A PROPOSED CORE & SHELL FOR

JESSE & SHERRIE TIX

10634 MALTESE POINT PEYTON, CO

Site Plan_v2_redlines.pdf Markup Summary

Sheet Title: SITE PLAN / COVER SHEET

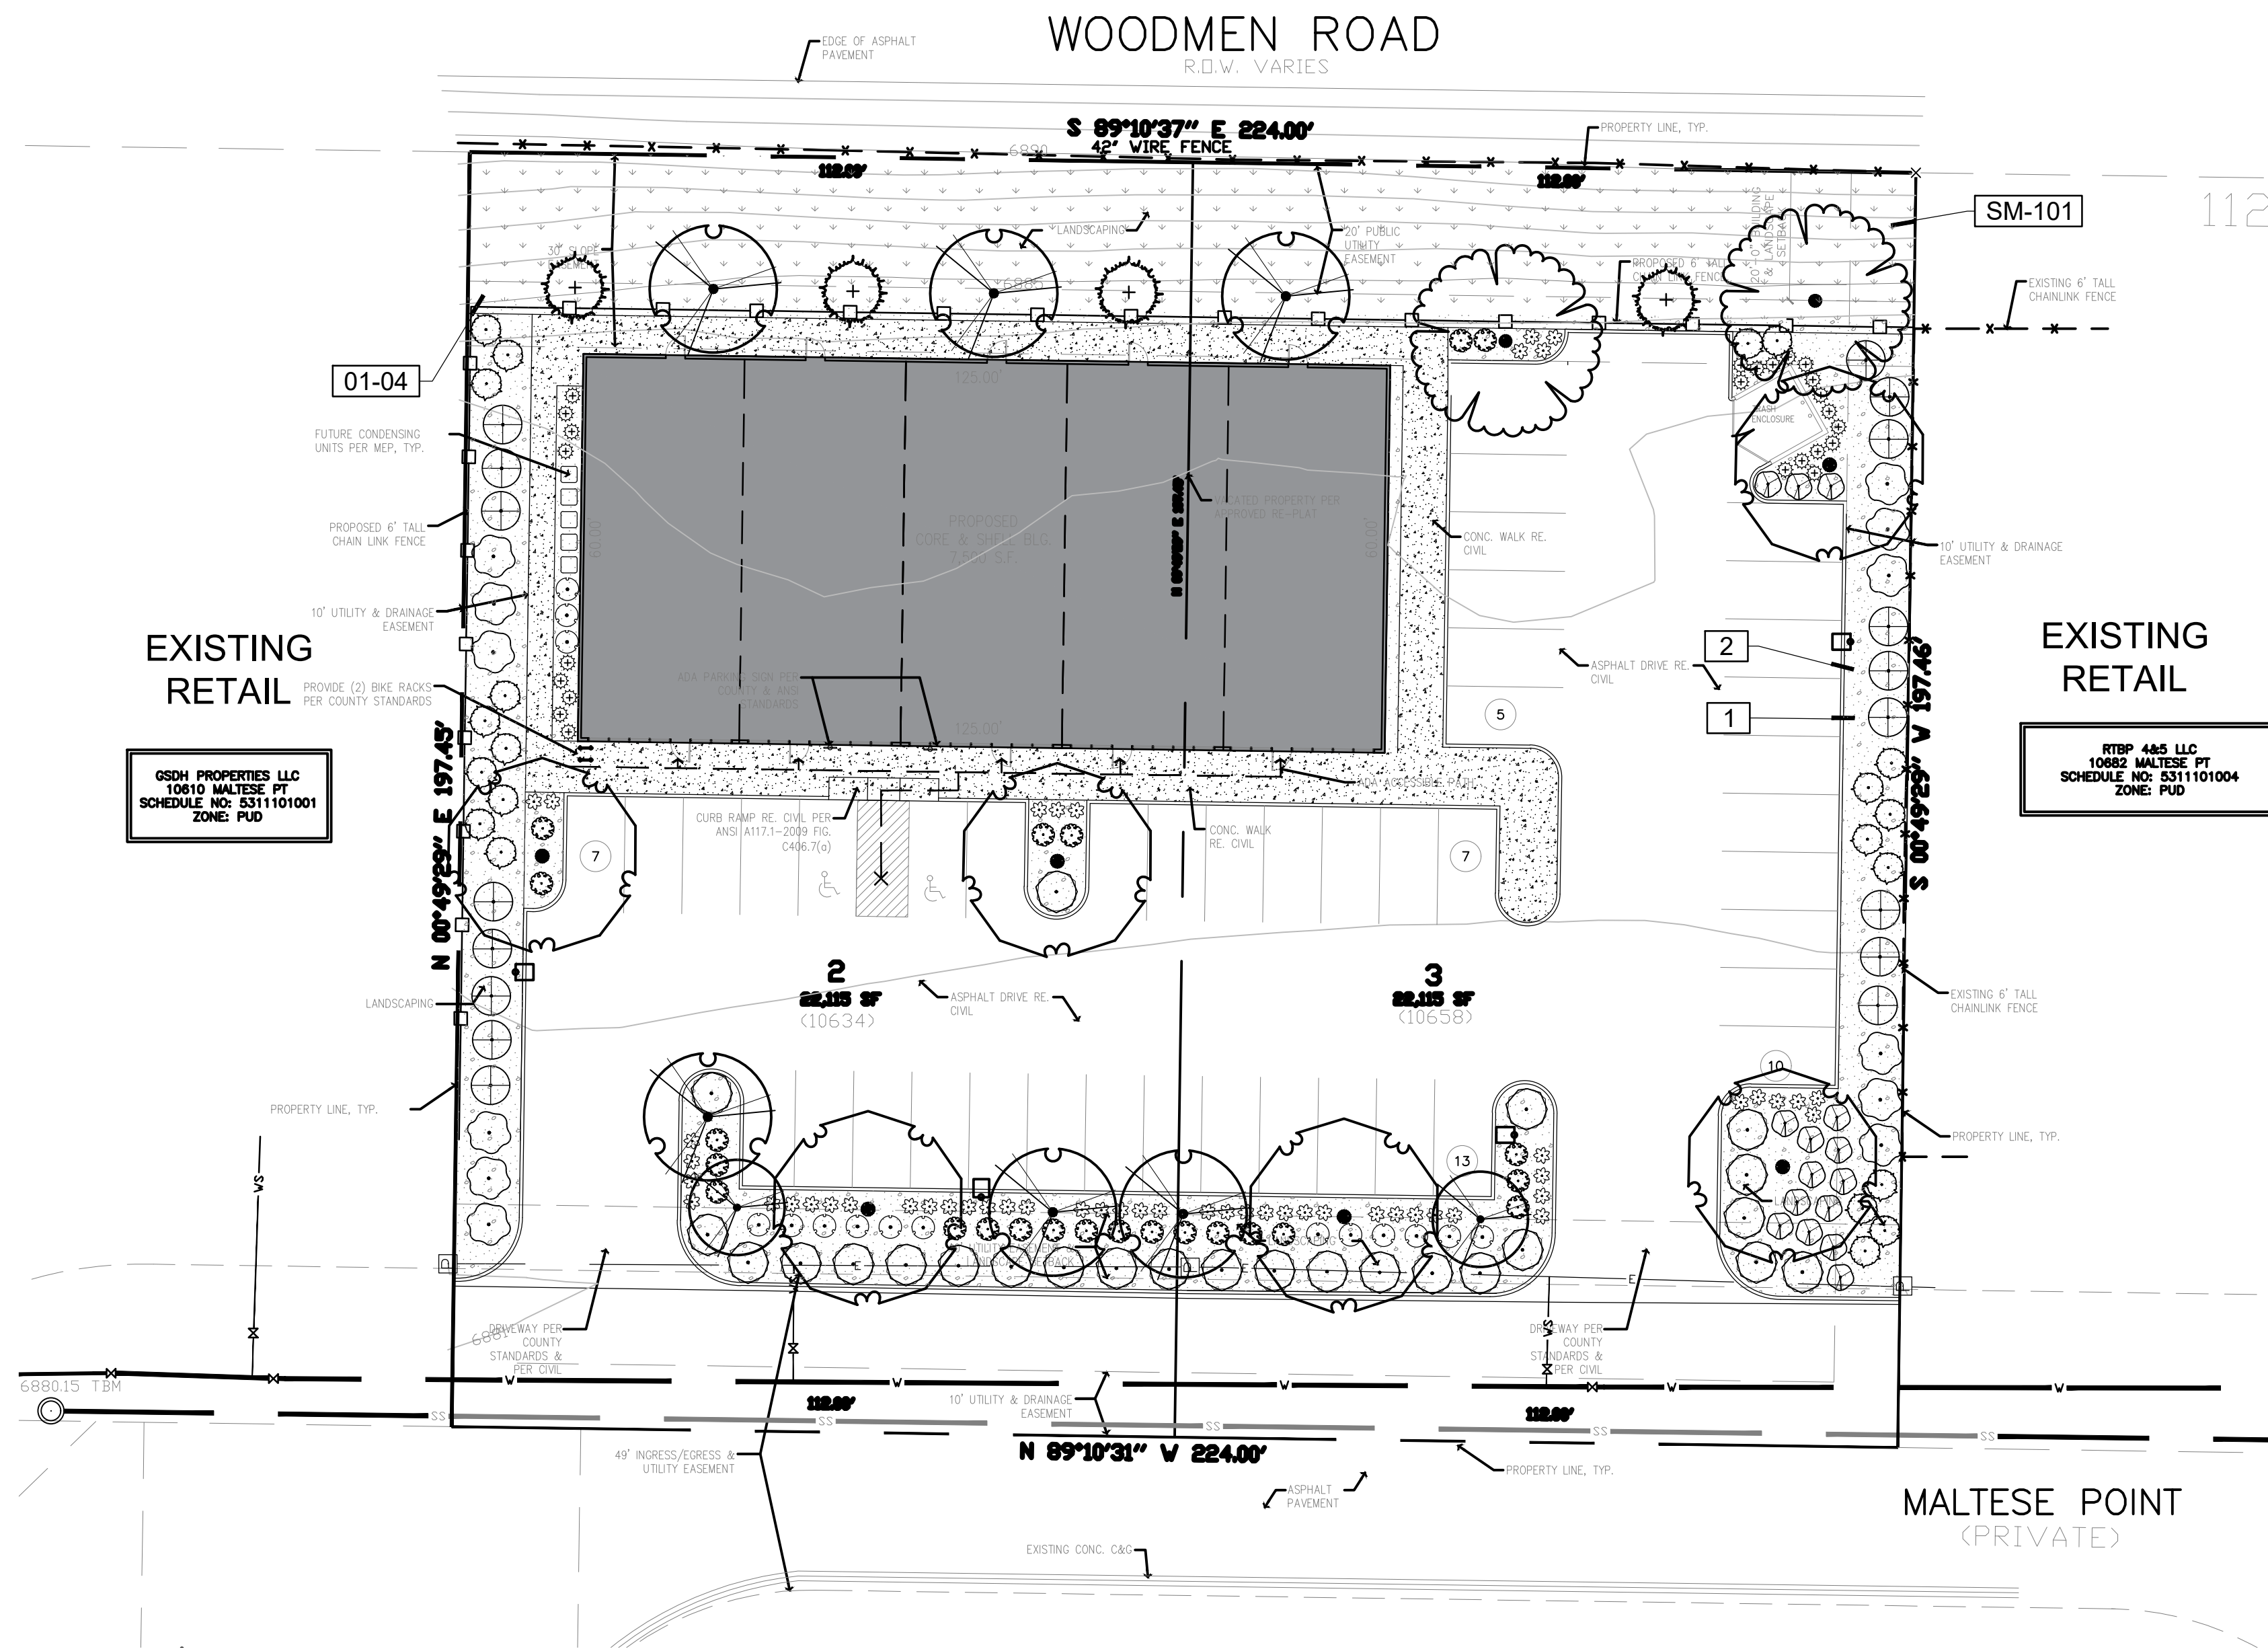
No.	Description	By	Date
1	Review 1 comment: Add PCD File No. PPR2010		
2	Review 2: Unresolved. If you are using the same site plan that was used in the special use application then both file numbers may be added to the plan

Verify that dumpster can be serviced in this location. In some cases, the providers do not want to back out into the street.

Review 1 comment: Please label the property line
Review 2: Unresolved. Please label the property line or provide a legend showing the line type of the property line.

Where will the HVAC units be located? If adjacent to the building at grade, please revise sidewalk around the building to accommodate them

Where will the ADA parking sign be installed?

Allowed in 30' slope easement?
